**From:** Patz, Logan W.  
**To:** ["Eddings, Scott"](#)  
**Subject:** 1505 Candelaria Rd. NW, Valley High school, G13D010 CO Comments  
**Date:** Friday, March 10, 2017 10:26:00 AM  
**Attachments:** [Pic Traffic.docx](#)

There are a few items that need to be addressed before we can release the perm CO. Pictures attached.

C-102A
SHEET 5A OF 133

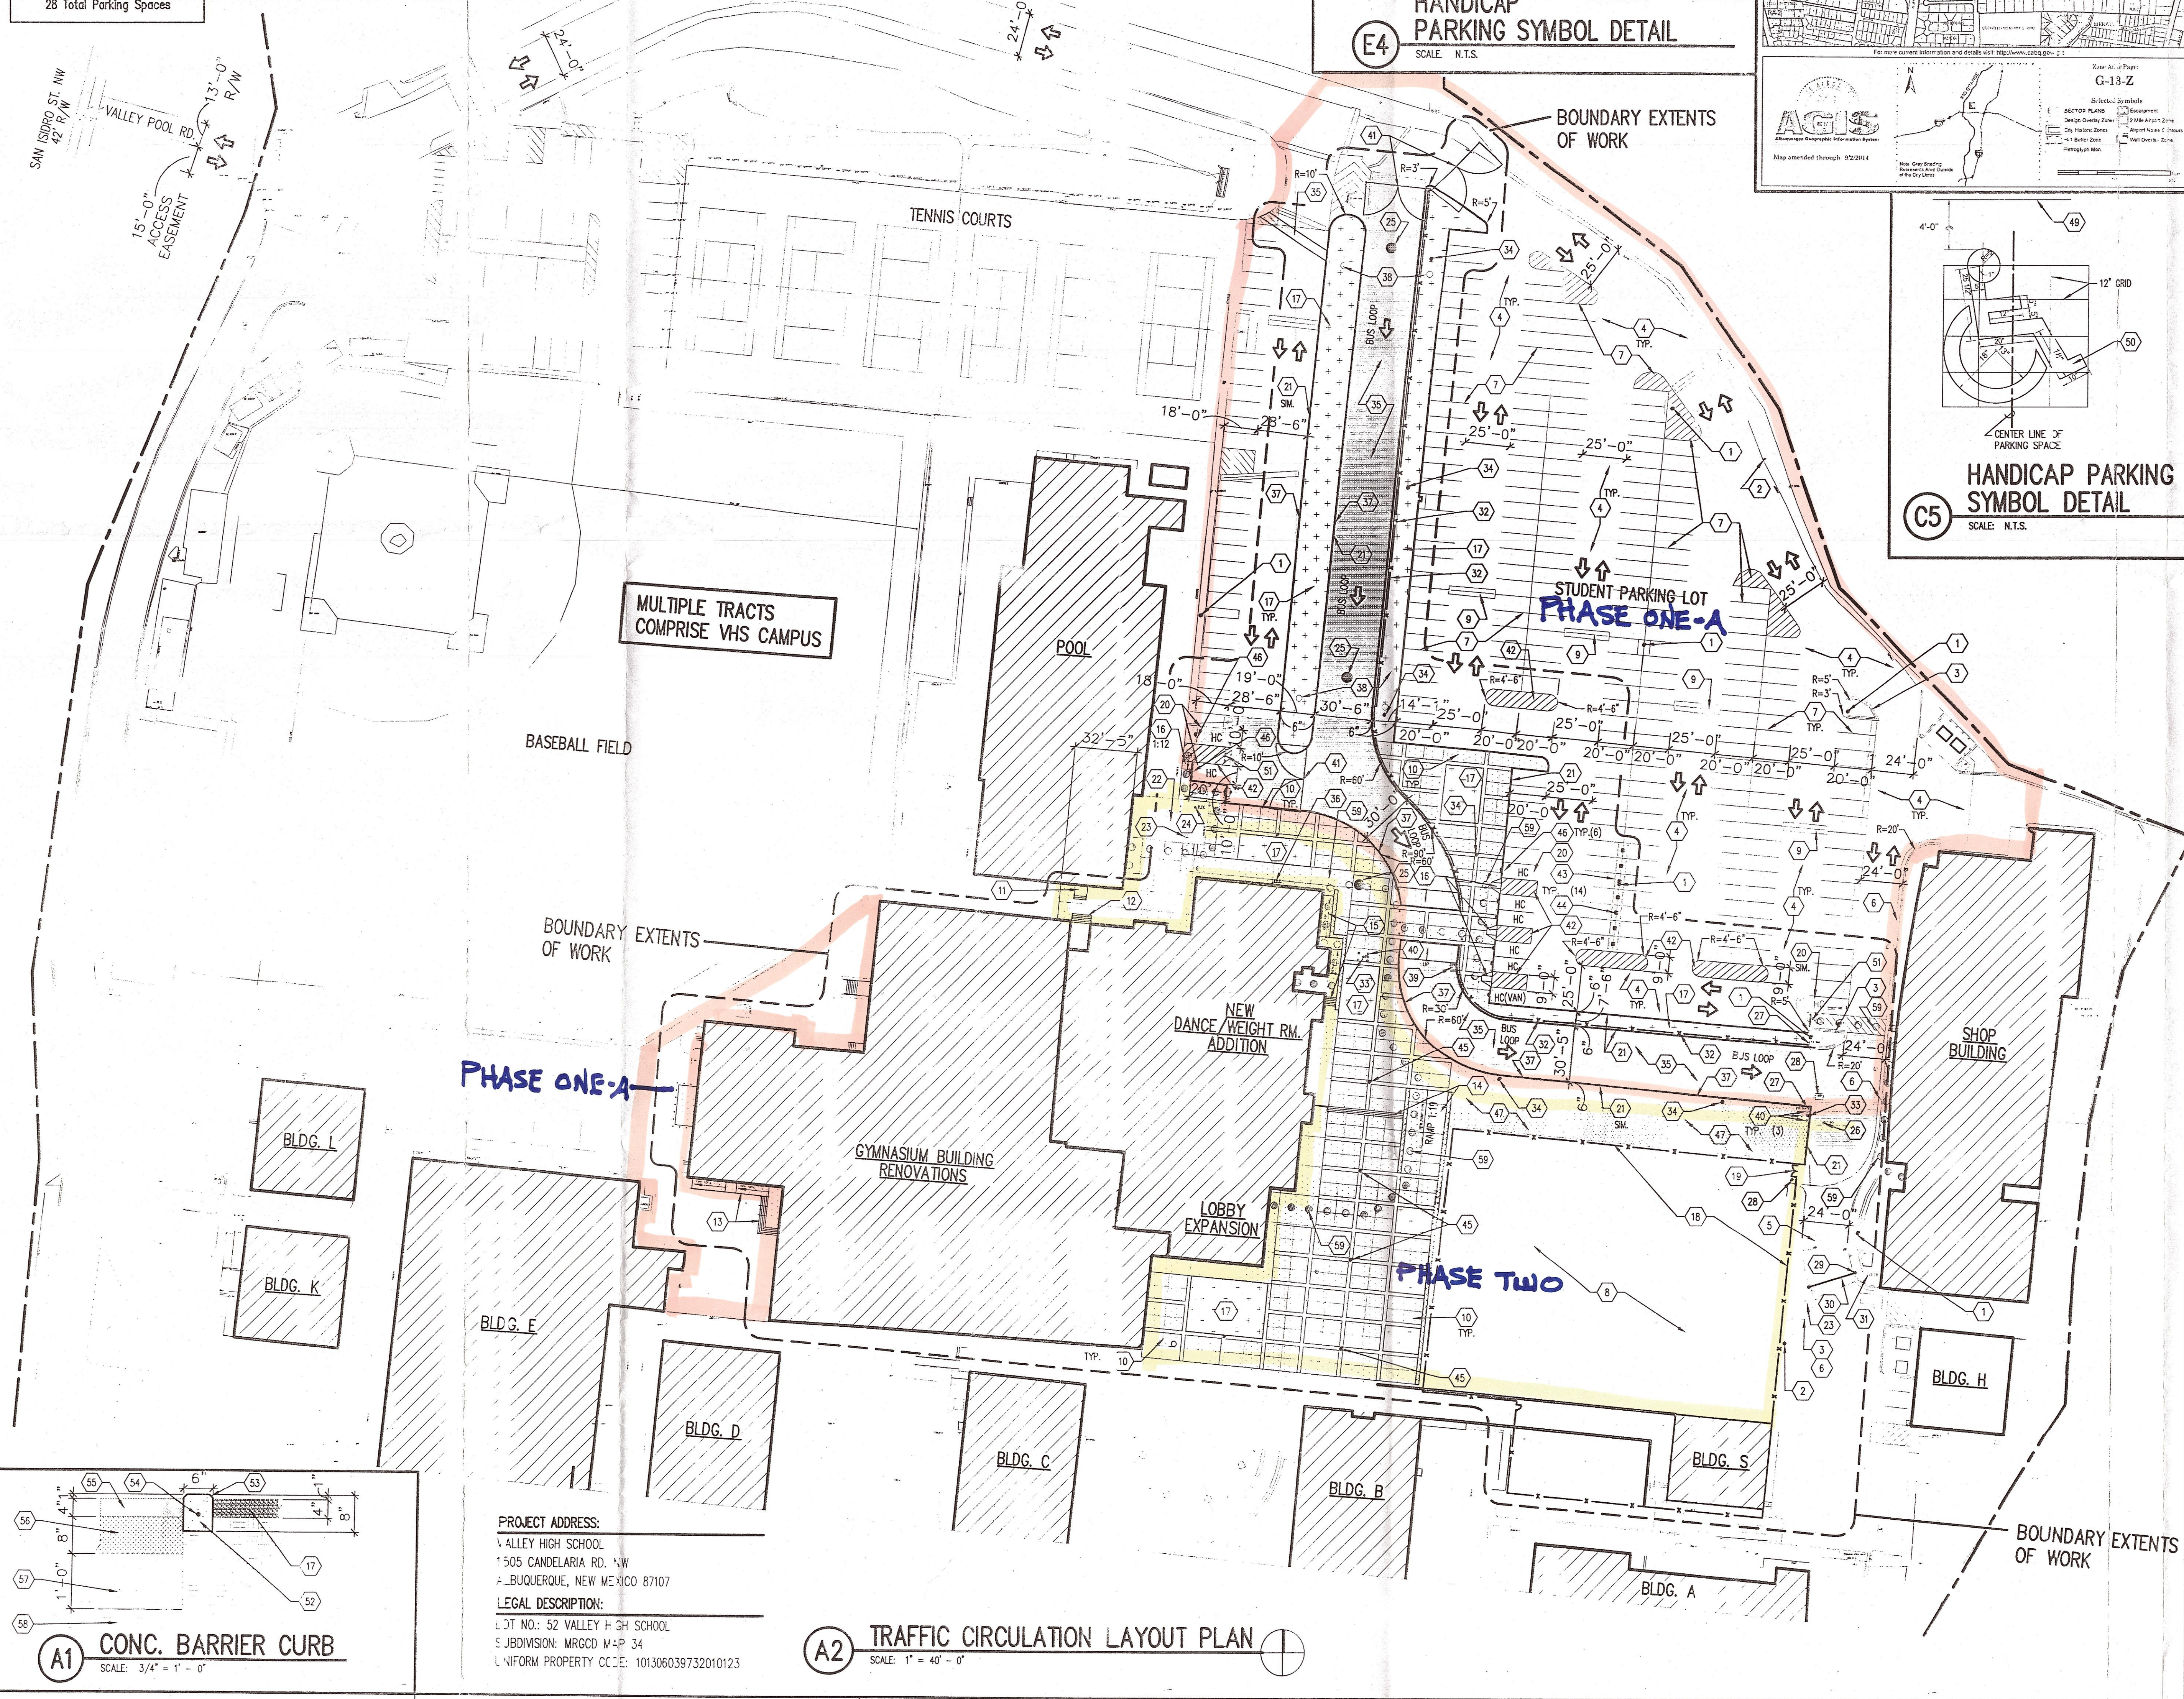
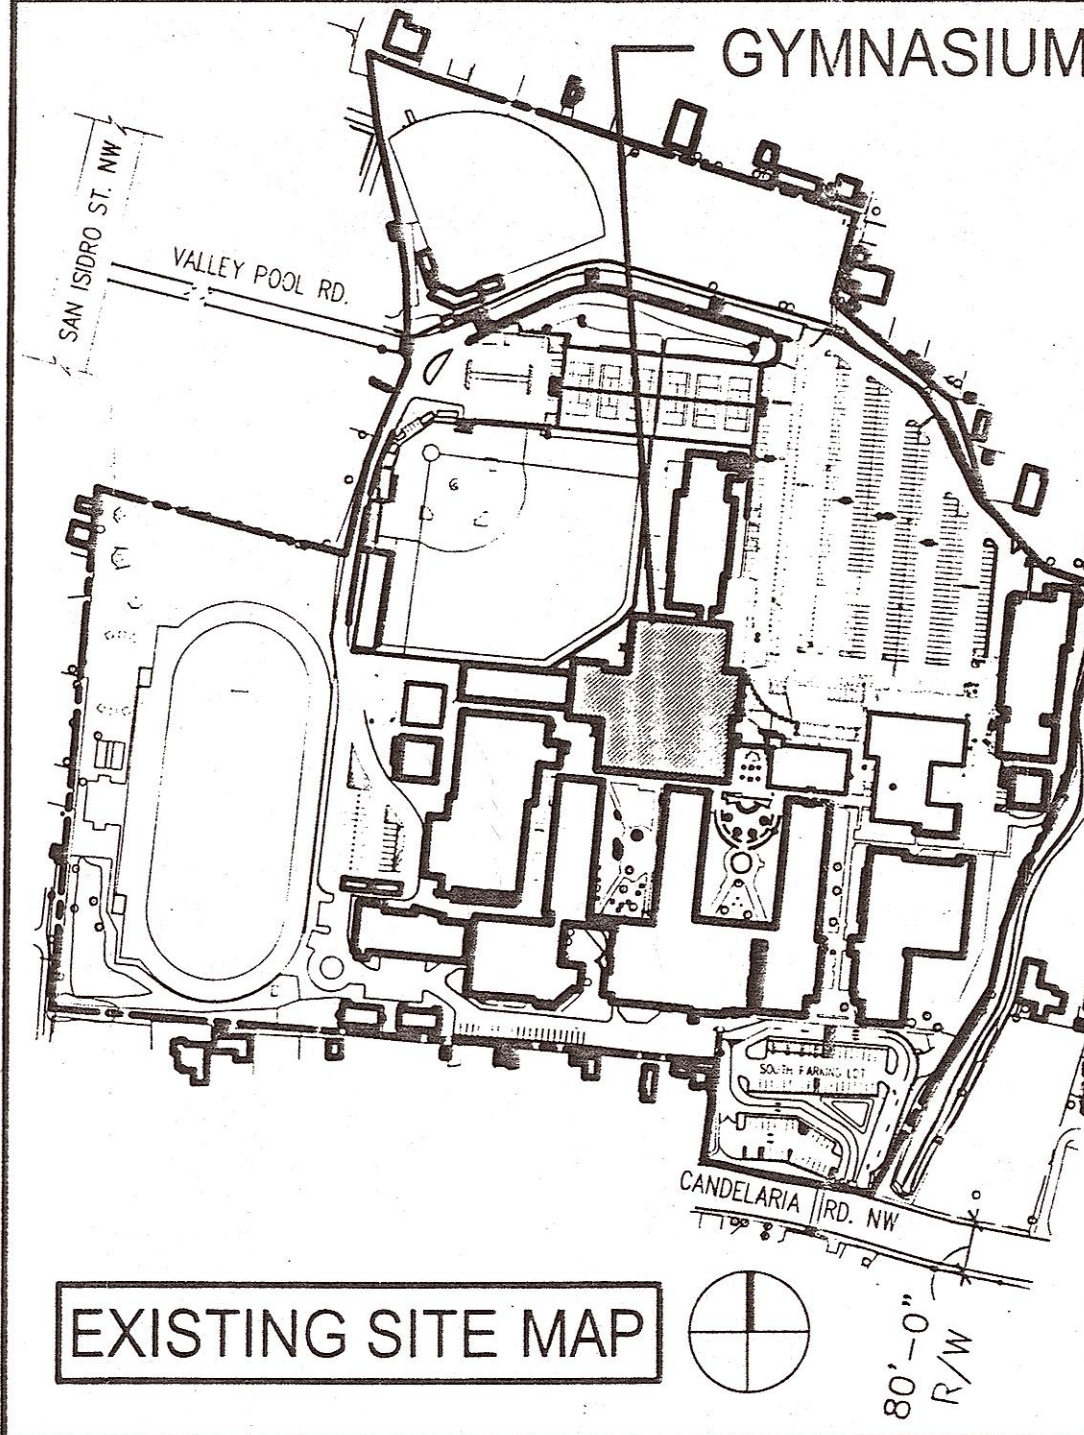
The ADA (handicap) sign should be updated.

There are poles around a portion of asphalt that has rutting. This should be fixed and removed.  
How will the drainage at the bus entrance be addressed.
